SITE STUDY

VIEW ANALYSIS

In response to the City of Sydney's comments regarding the southern façade treatment and opportunity for public artwork.

DRAWING SERIES  
Elevations  
DRAWING TITLE  
Northern Elevation + Southern  
Elevation

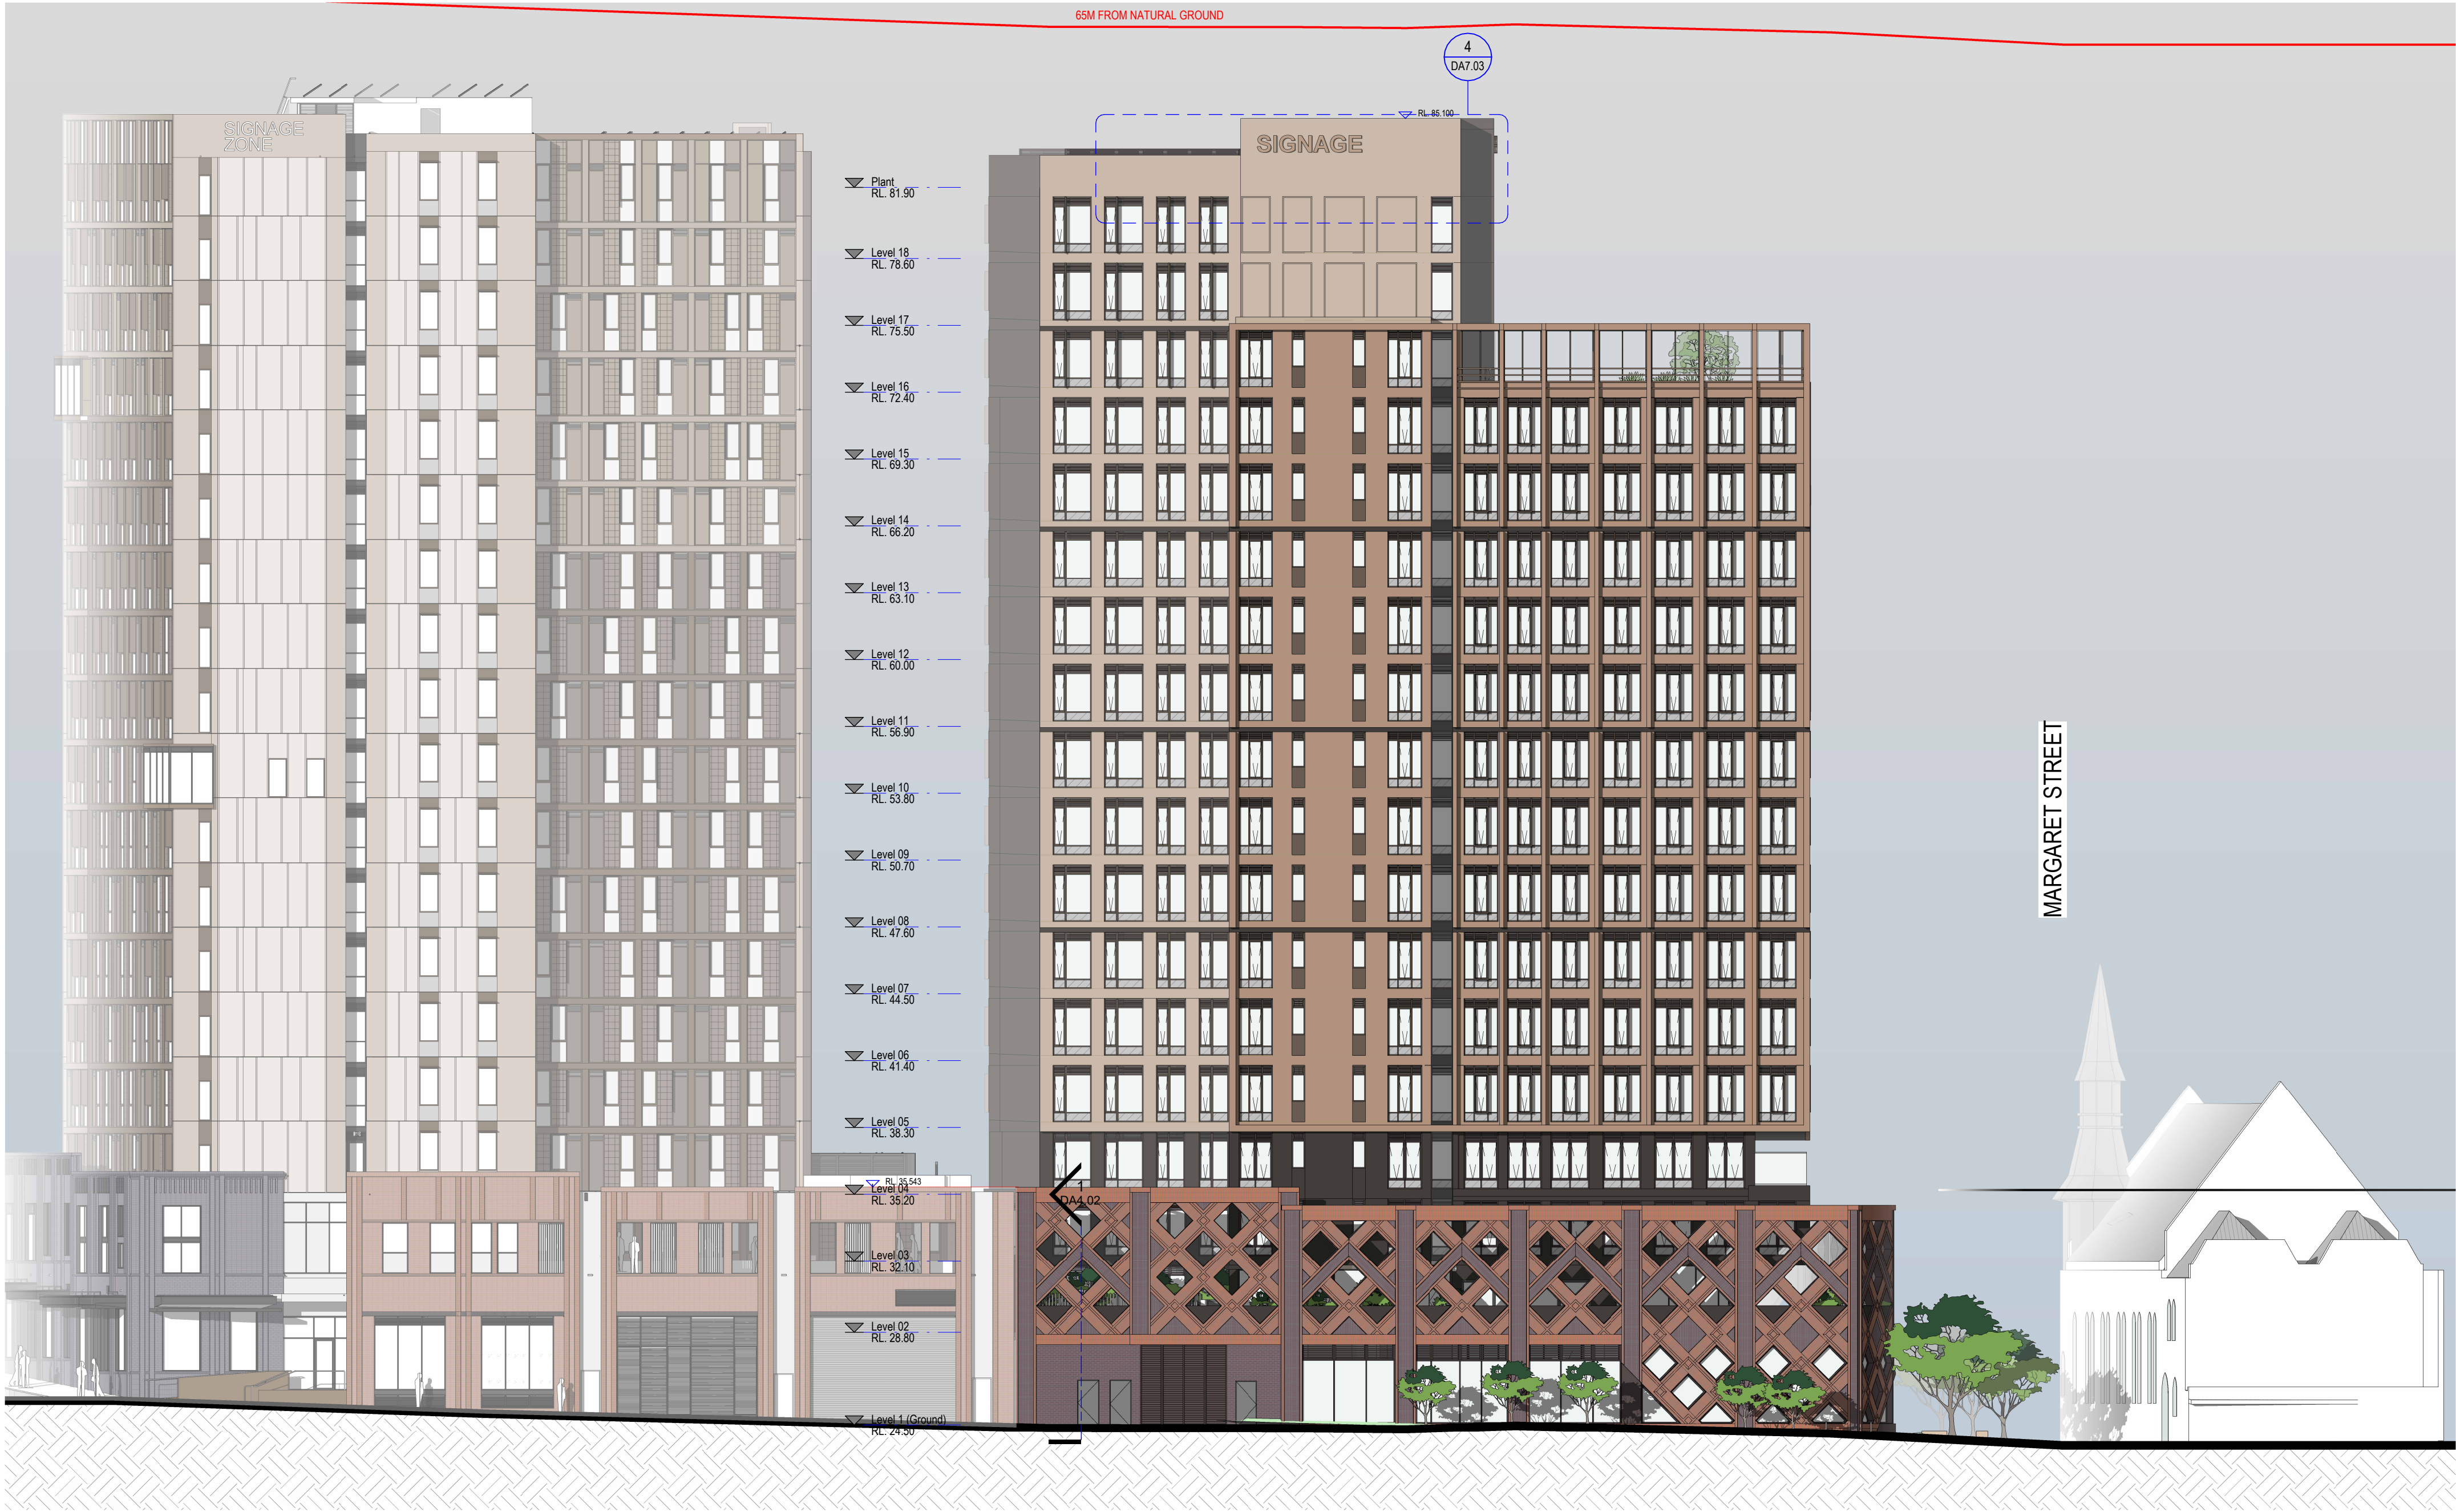
We undertook a visual study of the southern façade to understand the extent that it would be visible from a range of local vantage points along the main arterial roads (Regent Street and Gibbons Street).

We identified that the southern facade is visible from both sidewalks along Regent street with a range of approx 137m - 165m (View 02 + View 10). Gibbons street sidewalk has a vantage of the southern facade at a distance of 120m depicted in View 19. In addition we have identified that the North East Corner of Daniel Dawson Reserve, where William Lane and Boundary Street intersect also has a prominent vantage of the southern facade (View 14) at a distance of 150m. The study has showcased that the top 5 storeys of the southern tower form of the building will be most visible.

In order to develop the artwork we engaged with local indigenous artist Nicole Monks, who has provided artworks for the adjacent 13-23 Gibbons Street and 90-102 Regent Street buildings.

We presented Nicole the two 5 storey "blank Canvas" areas that required an artwork with the indigenous influence. Taking inspiration from the weaving pattern of the podium façade Nicole suggested that this building should provide a more feminine artwork in contrast to the masculine artwork of 90-102 Regent St building.

Nicole, having recently undertaken a photographic workshop with award winning photographer Wayne Quilliam and the Brolga Dance Company, has suggest incorporating an image of the dancers into the precast.

We are currently working through the copyright issues and permissions for the image prior to engaging the precast manufacturer.
